# Consultee Comments for Planning Application 23/02901/FUL

Application Number: 23/02901/FUL

Proposal: Demolition of existing glass house and construction of 2 no. units of 2 bedroom tourist accommodation and associated works.

Name: ?-? Environmental Strategy Unit

**Proposed floor plan**  
Scale 1:100@A3

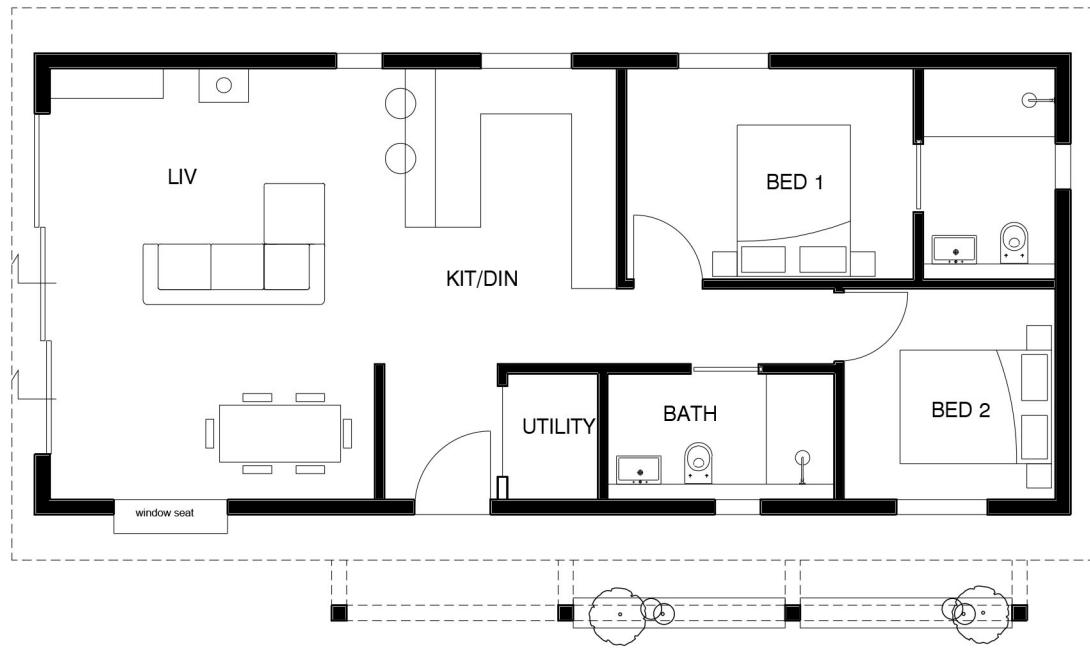
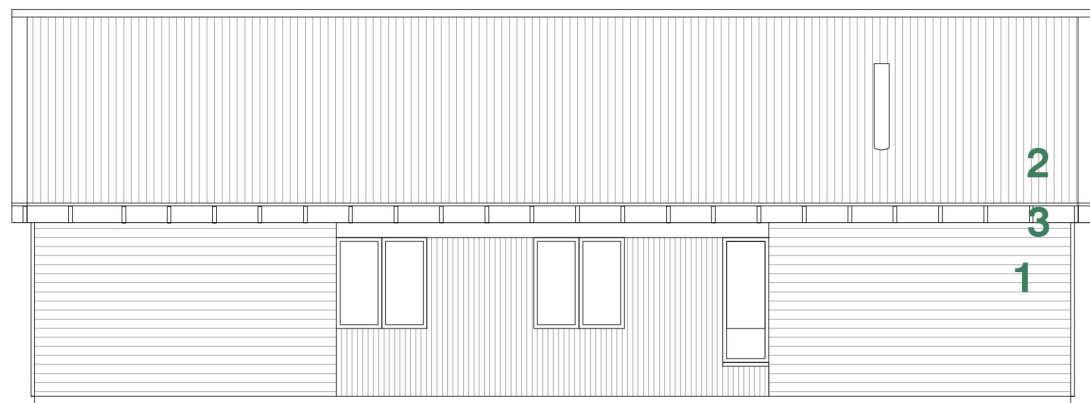
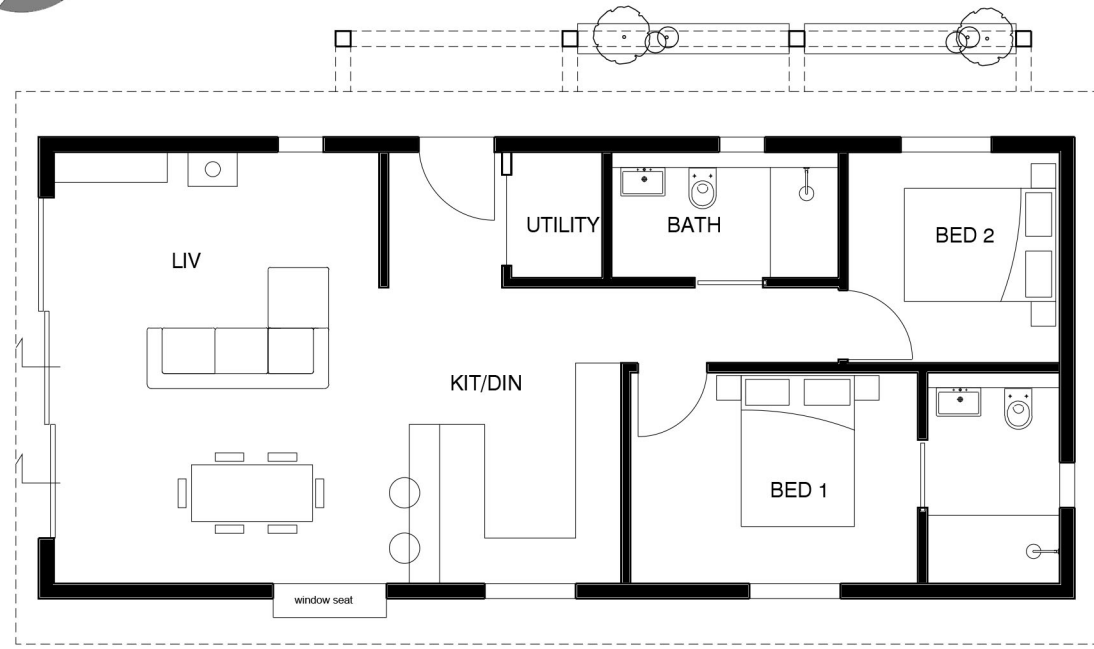
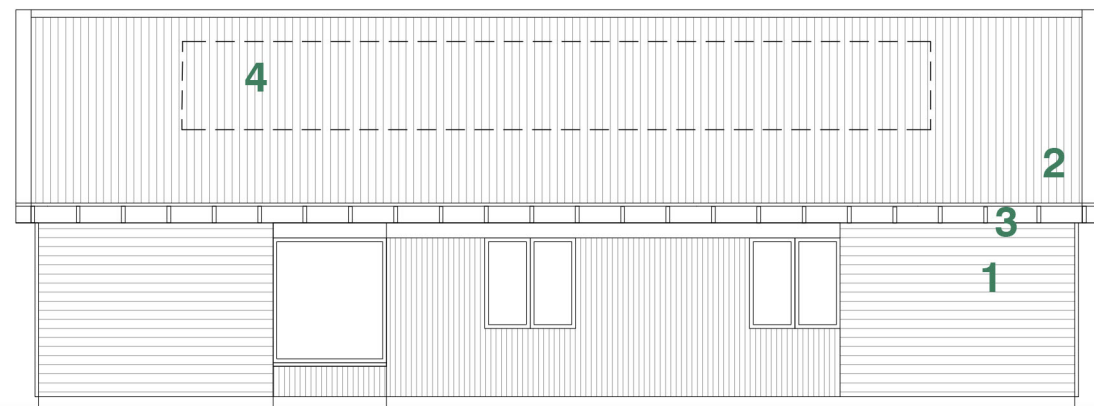
We require that a bat box is installed on the buildings onsite facing south/south westerly positioned 3-5m above ground.

We would like a bird box to be installed on the building / and or tree within the garden of the property.

Proposed Site Plan
Scale 1:250@A3

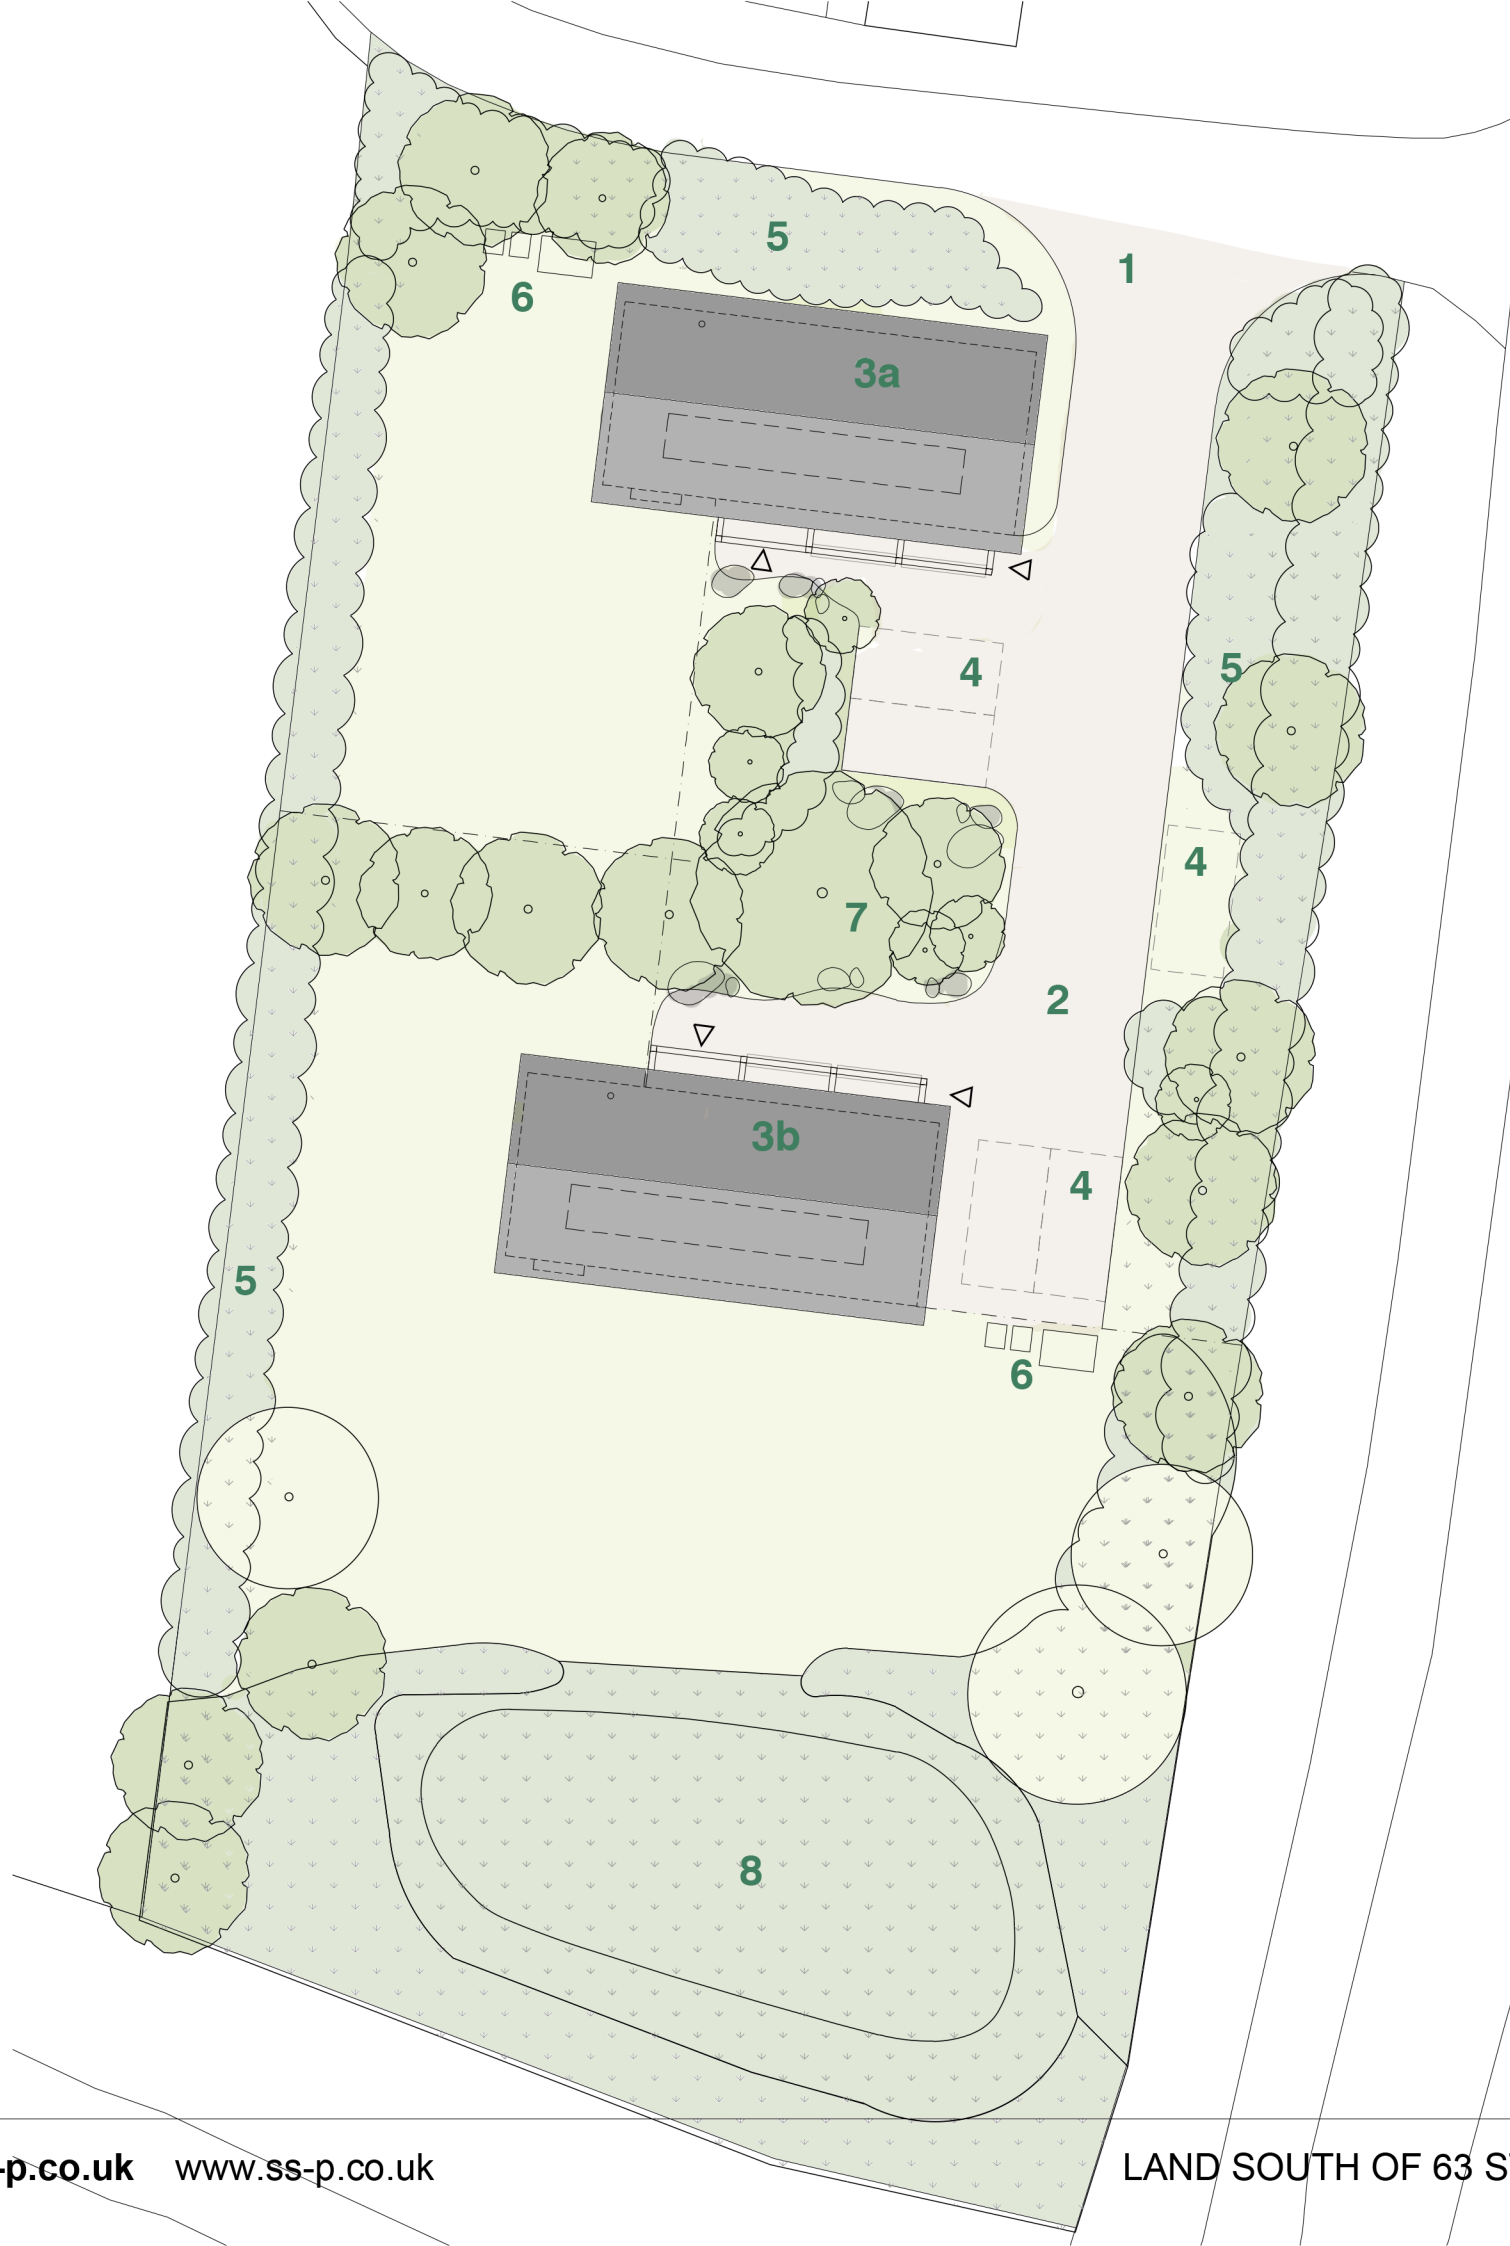
The hedgerows, woodland and treelines on site may be used by dormice for commuting, nesting and foraging and will need to be retained and enhanced for dormice. This will include having a buffer strip around the hedgerows (5m) and during construction fencing should be used to ensure this area is undisturbed. Any gaps should also be filled in using native hedge species to improve connectivity. Conditions should be used to ensure this.

The hedgerows on site are used by bats for commuting and foraging and will need to be retained and enhanced for bats. This will include having a buffer strip around the hedgerows (5m) and during construction fencing should be used to ensure this area is undisturbed. Any gaps should also be filled in using native hedge species to improve connectivity. Conditions should be used to ensure this.
